Re: State Significant Development Application SSD-55844212
Property: 39 Dehli Road, North Ryde (Lot 21 / DP 1003588)

I refer to the above-mentioned State Significant Development Application – Trinité Lighthouse Build-to-Rent exhibited on 28 September 2023 for:

Chapman Planning has been engaged by residents of Ryde Gardens – Buildings A and B (our client) to review the above-mentioned application and prepare a submission objecting to the proposed development. Chapman Planning does not have any reportable political donations to declare in accordance with the donations and gift disclosure requirements and acknowledges the department's disclaimer that the submission will be publicly available.

5.1 CAMERA POSITION 01 - RYDE GARDENS, 1 NETWORK PLACE, RL109.0

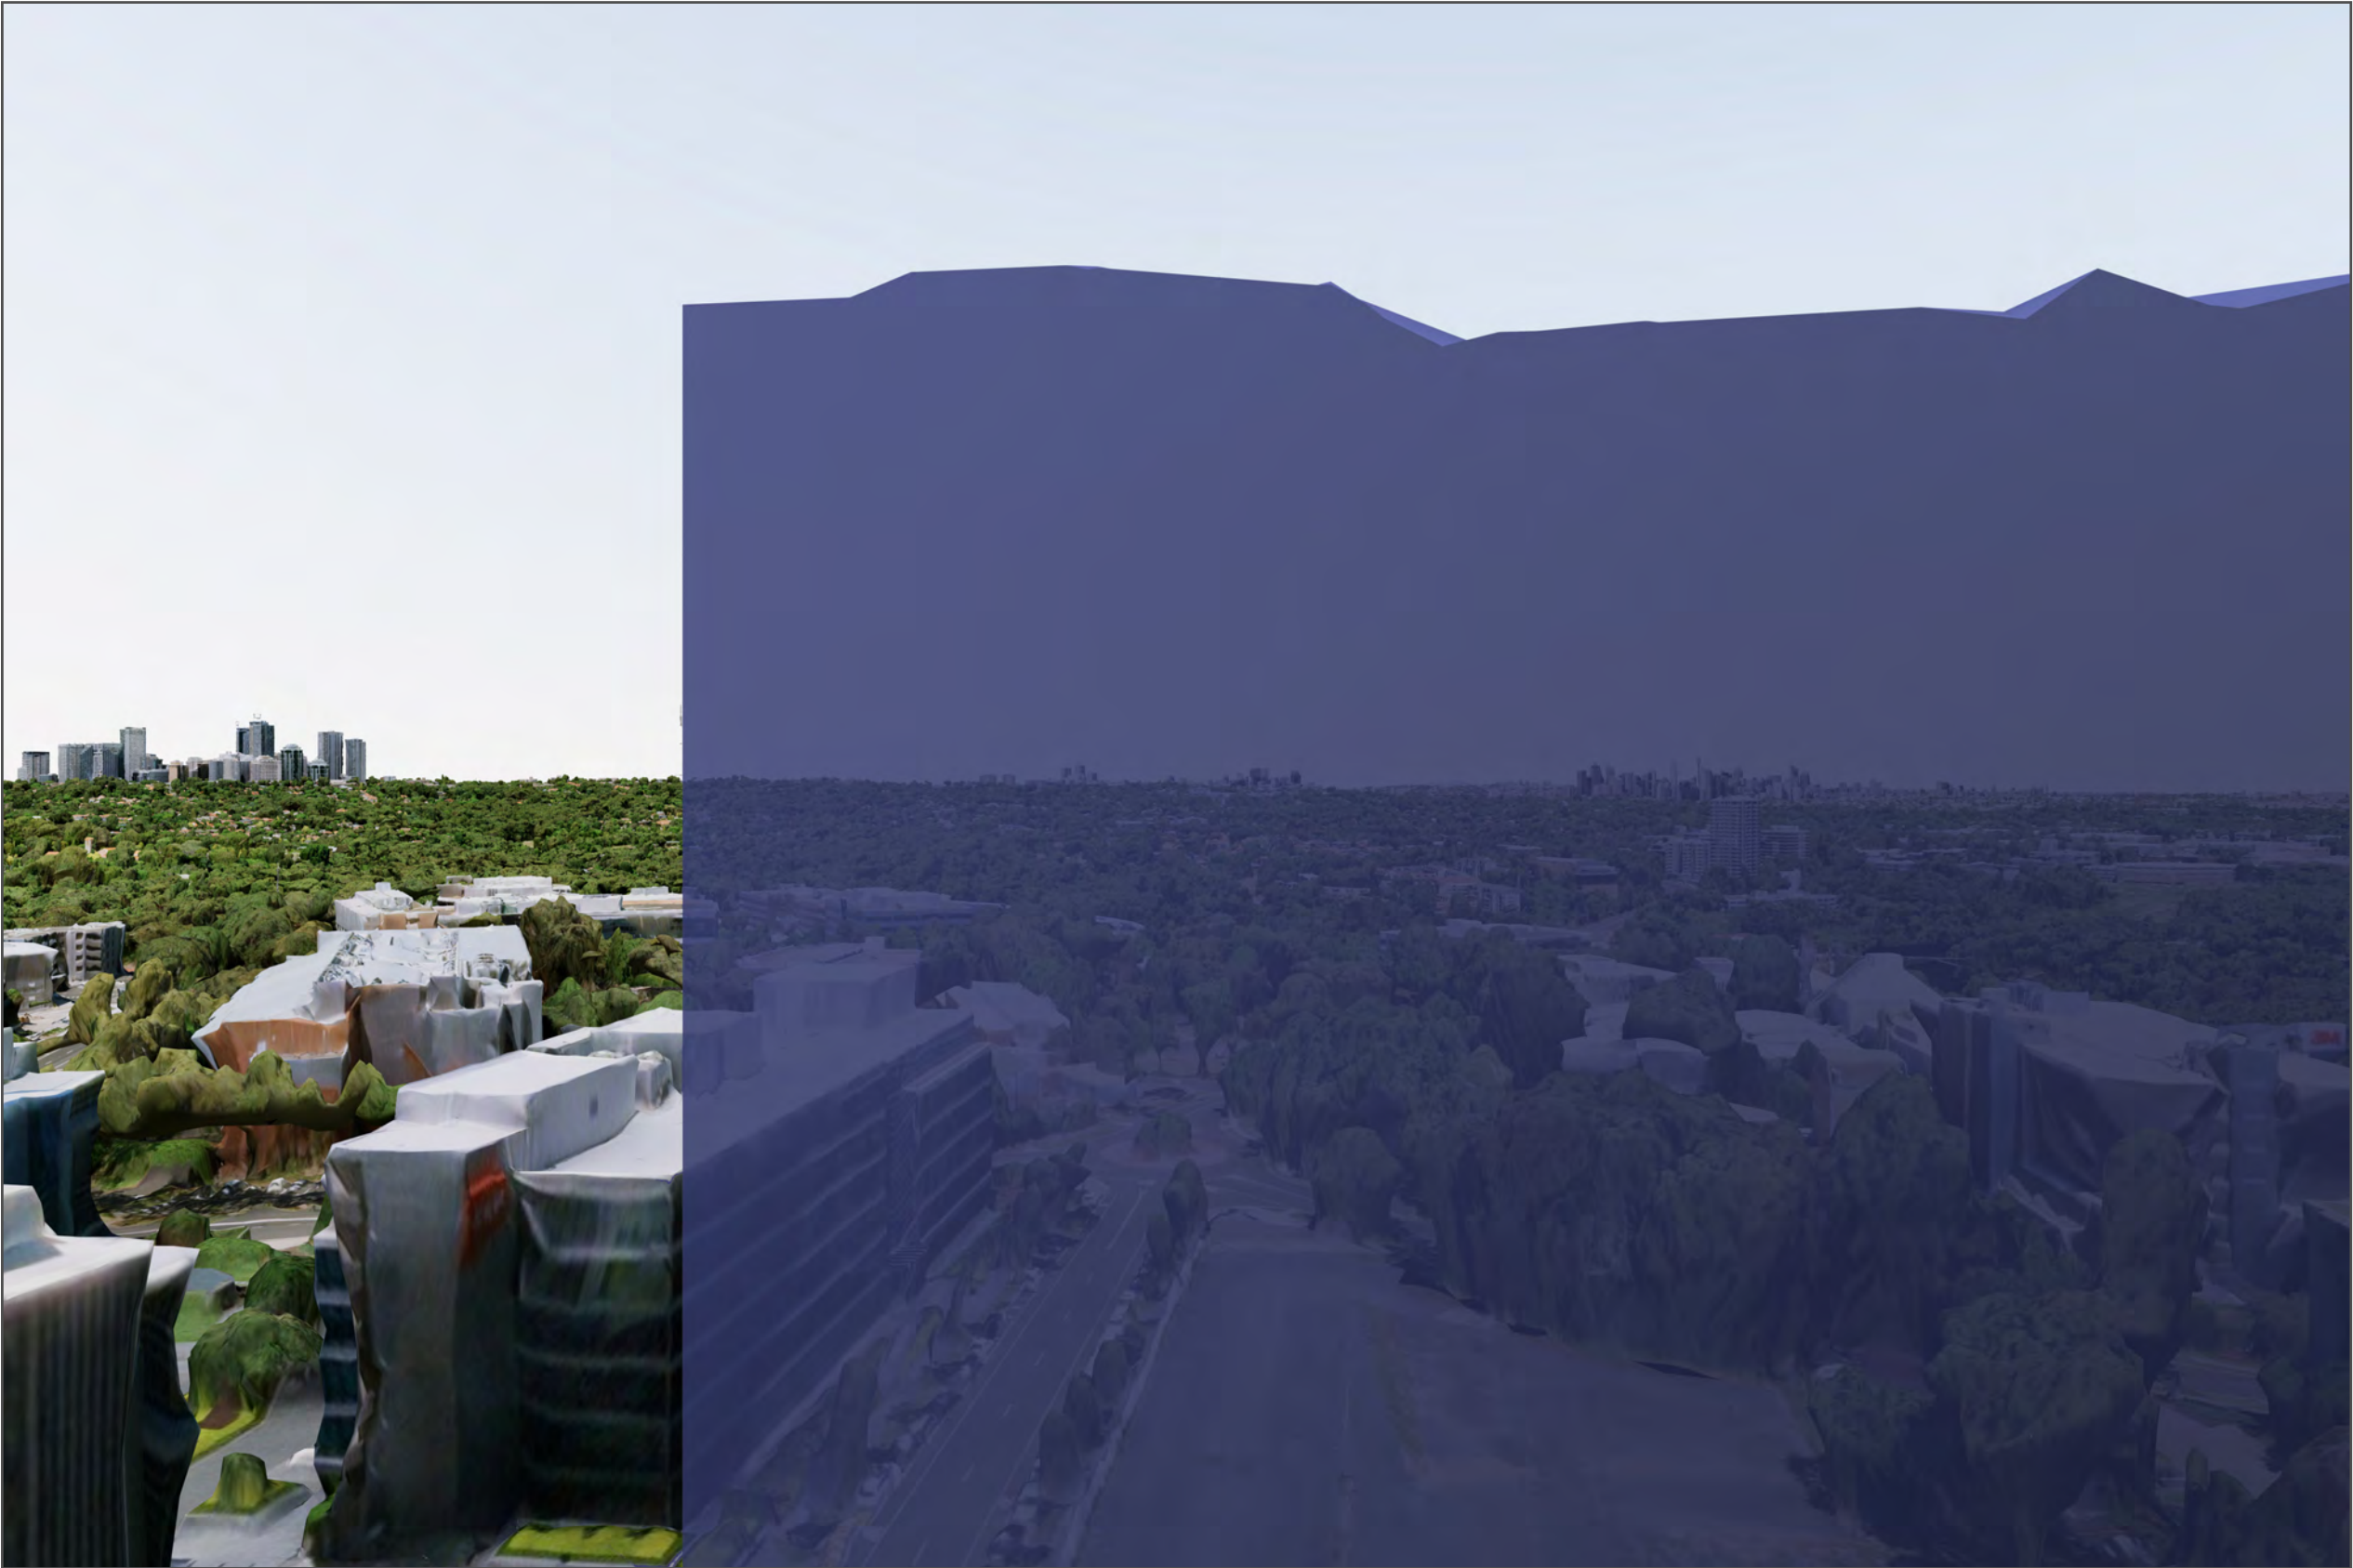
As a result of the additional density sought by the application under the proposed non-compliance with Clause 6.9 of the Ryde LEP, the development will have significant view loss impacts upon existing high density residential towers to the west at 1-3 Network Place, North Ryde – Ryde Gardens buildings. In particular, the views currently enjoyed by the residents of the northern tower of the Ryde Gardens site at the mid-upper levels will be devastated by the proposed development, noting these views are obtained directly opposite the site as depicted in the SIXMaps extract below:

The submitted view impact analysis acknowledges that the views enjoyed by these buildings are primarily to the east across the subject site, and include district and landscape views of Lane Cove National Park in the foreground, uninterrupted horizon views, and distant views of iconic landmarks including the Sydney CBD skyline, Sydney Tower, the Sydney Harbor Bridge, and views towards the North Sydney and Chatswood CBD skylines. The proposed development, with particular reference to the northern tower within Ryde Gardens, will have a devastating and unacceptable view loss impact upon the views enjoyed by residents from the mid-upper levels of these buildings.
